STATE OF NORTH CAROLINA
DEPARTMENT OF TRANSPORTATION

October 15, 2015

SUBJECT: **Request for Modification of the Section 404 Individual Permit and Section 401 Water Quality Certification** for the proposed East End Connector from NC 147 (Durham Freeway/Buck Dean Expressway) to north of NC 98 (Holloway Street) in Durham, Durham County, North Carolina, Division 5. Federal Aid Project No. NHF-76-1(2), TIP No. U-0071.

In addition to this cover letter, please find enclosed new Wetland Permit Drawing Sheet No. 1A of 91 and revised Wetland Permit Drawing Sheet Nos. 36, 74, 90, and 91 of 91.

SECTION THROUGH SILL

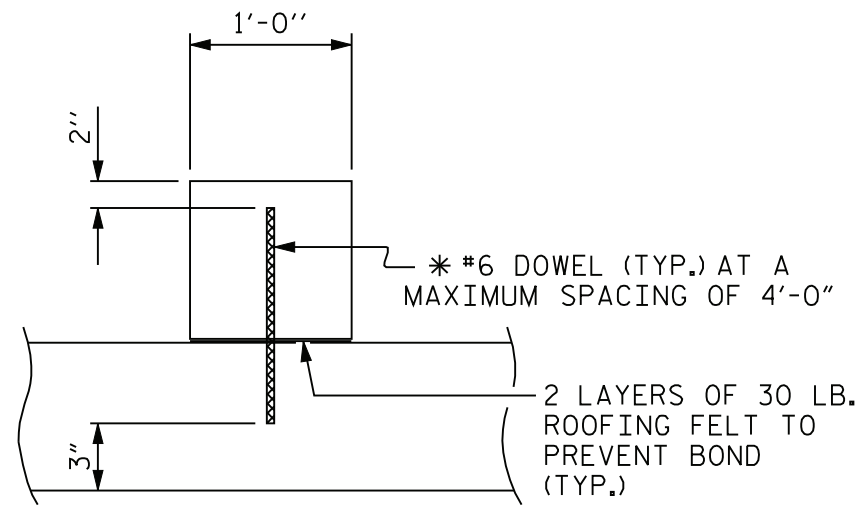
- **Culverts at 95+48 -L- Lt/Rt (Permit Site 7, Permit Drawing 36 of 91), 133+41 -L- Lt/Rt (Permit Site 17, Permit Drawing 60 of 91 [not included]), 34+45 -Y3- Lt/Rt (Permit Site 23, Permit Drawing 74 of 91), and 19+07 -Y4- Lt/Rt (Permit Site 7, Permit Drawing 36 of 91):** The contractor has completed installation of the single-barrel box culvert at 95+48 -L- Lt/Rt (Permit Site 7). The streambed has a headcut above the culvert inlet. The Department proposes to install a one foot sill at the inlet and outlet of the culvert at this location, as well as the other three culverts on the project (at Sites 7, 17, and 23). Please see added Wetland Permit Drawing Sheet No. 1A of 91 for the culvert sill detail.

Permit Drawing
Sheet 74 of 91
Revised October 2015

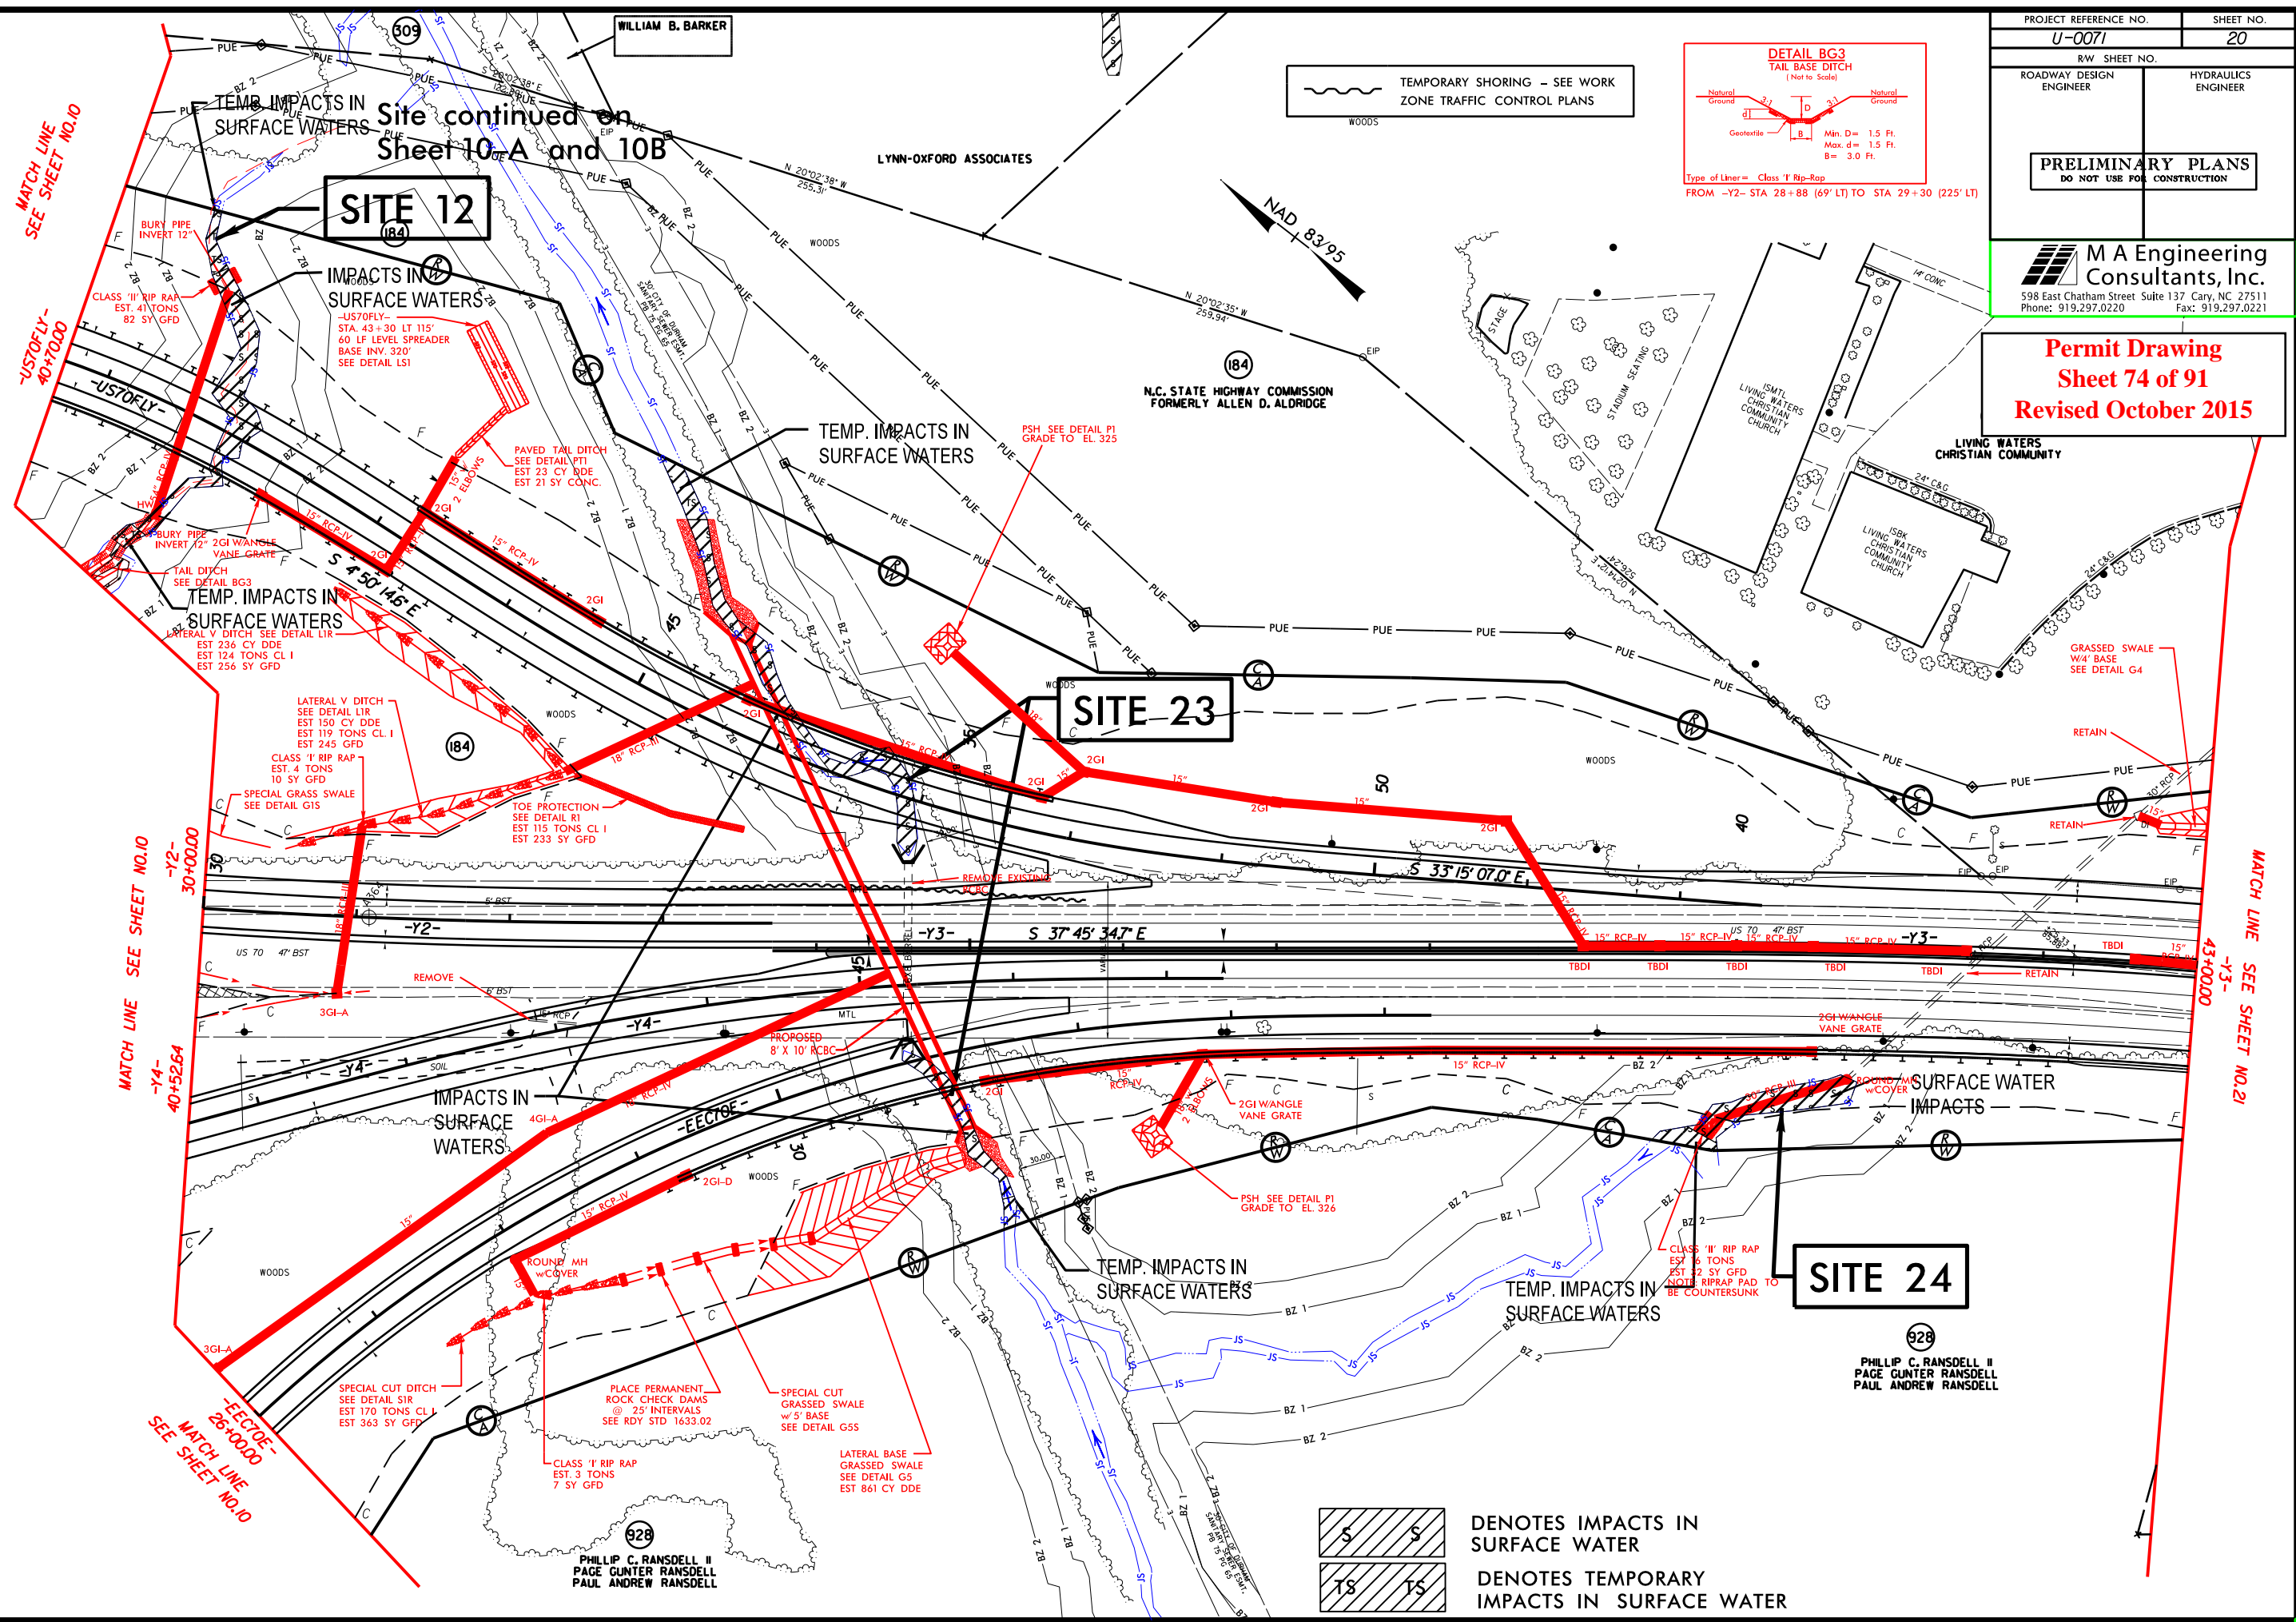
- **Permit Site 23 (Permit Drawing 74 of 91) at 45+00 -US70FLY- Lt:** The contractor is currently installing the single barrel culvert at this site. The Department has evaluated existing streambank stability downstream of the culvert and proposes to add additional Class II rip rap bank stabilization along both streambanks at the outlet to provide for enhanced permanent stability. This design change will result in a reduction in temporary stream impacts of 11 linear ft., a decrease in permanent stream impacts of 10 linear ft., and an increase in bank stabilization impacts of 13 linear ft.

- **Permit Site 12 (Permit Drawings 48 [not included] and 74 of 91) at 41+60 - US70FLY- Rt:** The original plan indicated construction of a tail ditch (with no flow line liner) to convey stream flow through the project. The Department has evaluated this design based on existing field conditions and now proposes to relocate the stream channel into a tail ditch with Class I rip rap in the flow line and on the banks. Please see Detail BG3 on Permit Drawing No. 74.
